ROAD SAFETY AUDIT STAGE 1: DESIGNERS RESPONSE

PROPOSED INDUSTRIAL DEVELOPMENT

Wappy Springs Inn, Lindley Moor Road, Lindley Moor

The RSA identified two problems, which required amendments to the proposals which are now shown on drawing 2102511 rev A.

TITLE
DRAINAGE LAYOUT

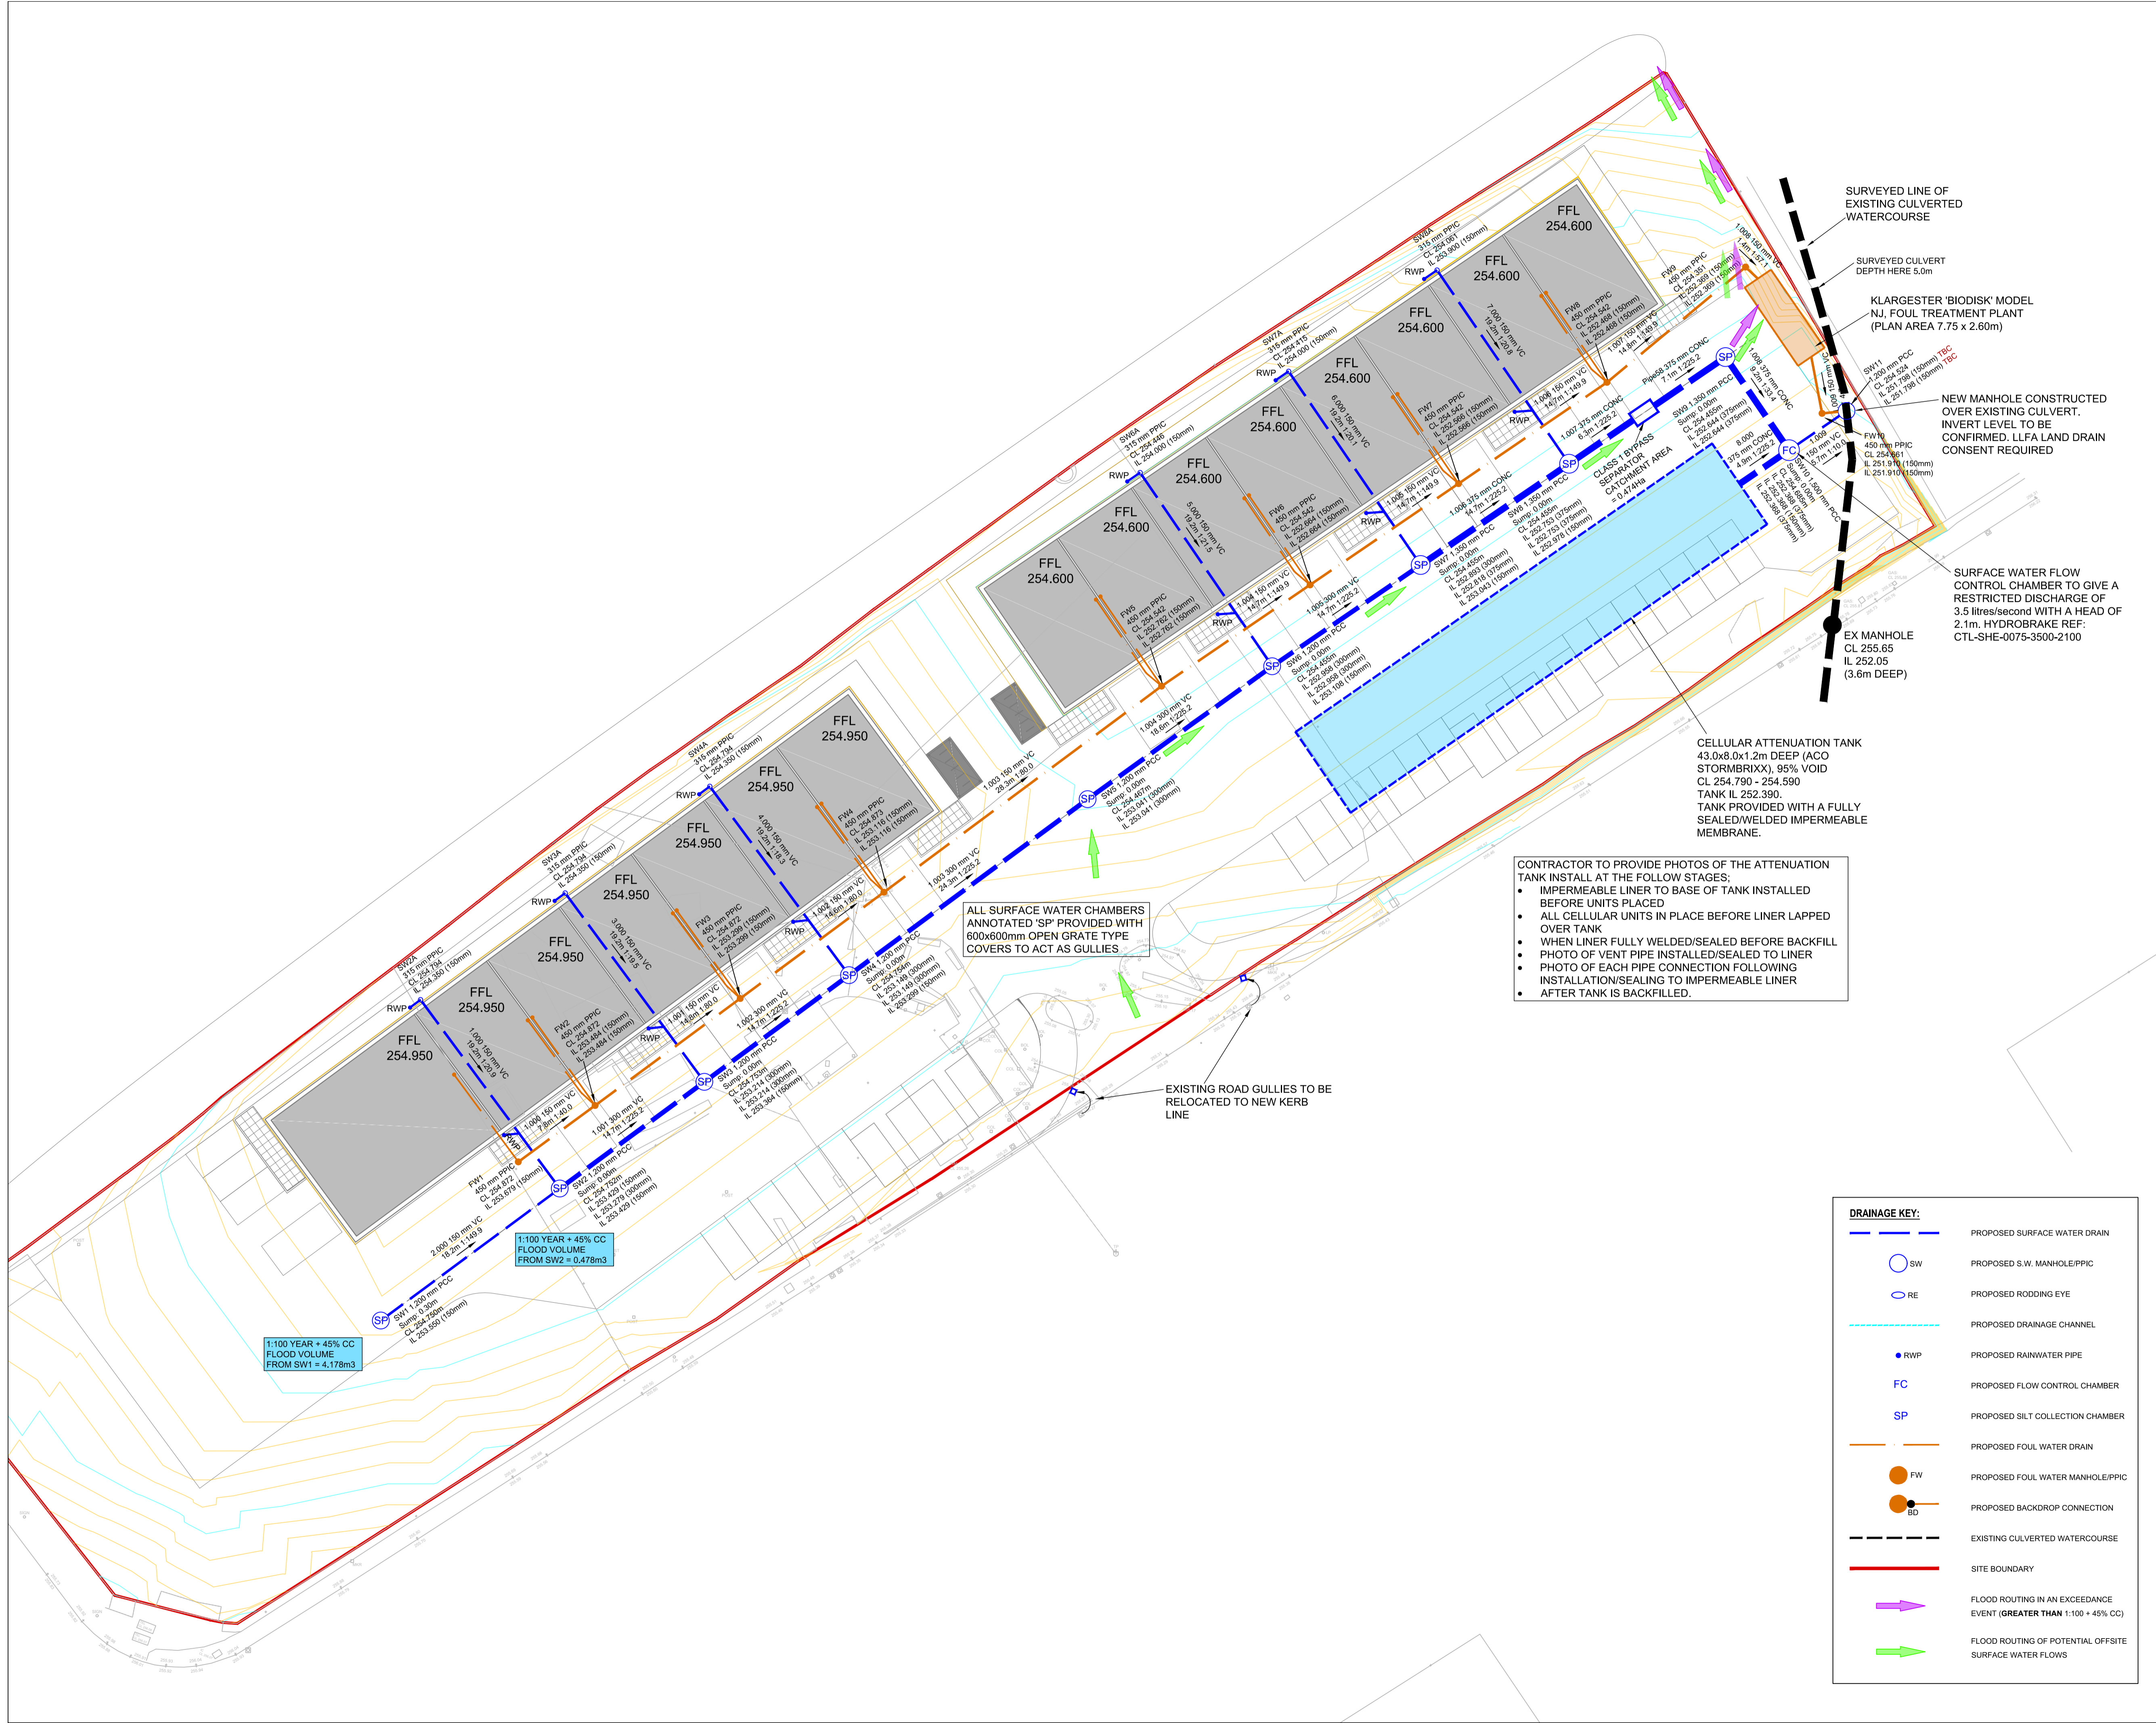
RSA Problem	RSA Recommendation	Design Organisation Response	Overseeing organisation Response	Agreed RSA Action
A-01 No drainage details provided / shown on drawings	Sufficient drainage to be provided			
A-02 Lack of Pedestrian Facilities	Footways around access now extended to flank the access on both sides
